WISWELL PARISH COUNCIL

Planning Application No: 3/2014/0831
Outline proposal for residential development of around 25 dwellings
Land off Whiteacre Lane, Barrow, Lancashire, BB7 9BJ

The above application has now been considered by the Parish Council. Members strongly object to the proposals and have made the following comments:

Tree survey plan

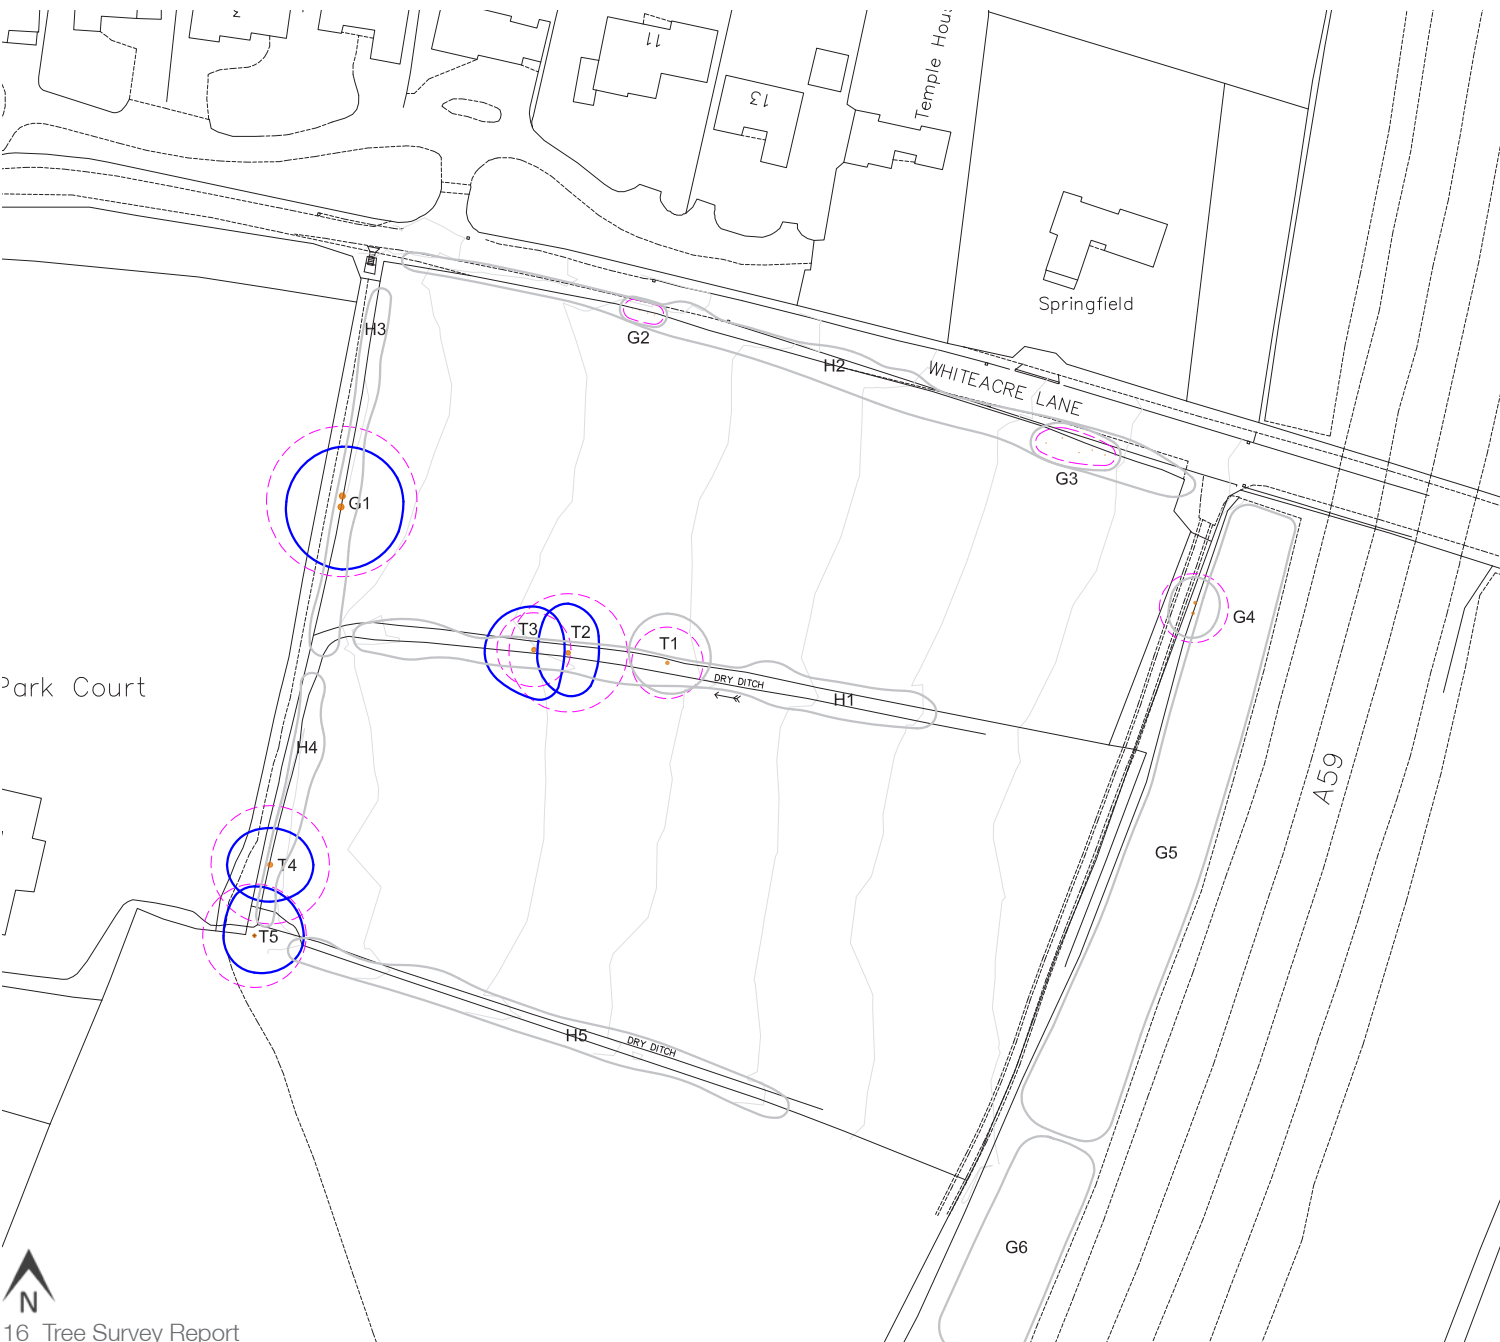
9. Members have concerns regarding the removal and relocation of the hedgerows, particularly the hedgerow fronting onto Whiteacre Lane which is estimated to be over 100 years old. The hedgerows must be protected as they support numerous types of wildlife, including bats, birds, dormice and insects which would be lost if the hedgerows were removed. Many local people make a point of regularly looking at and checking the wildlife along this lane on a regular basis.
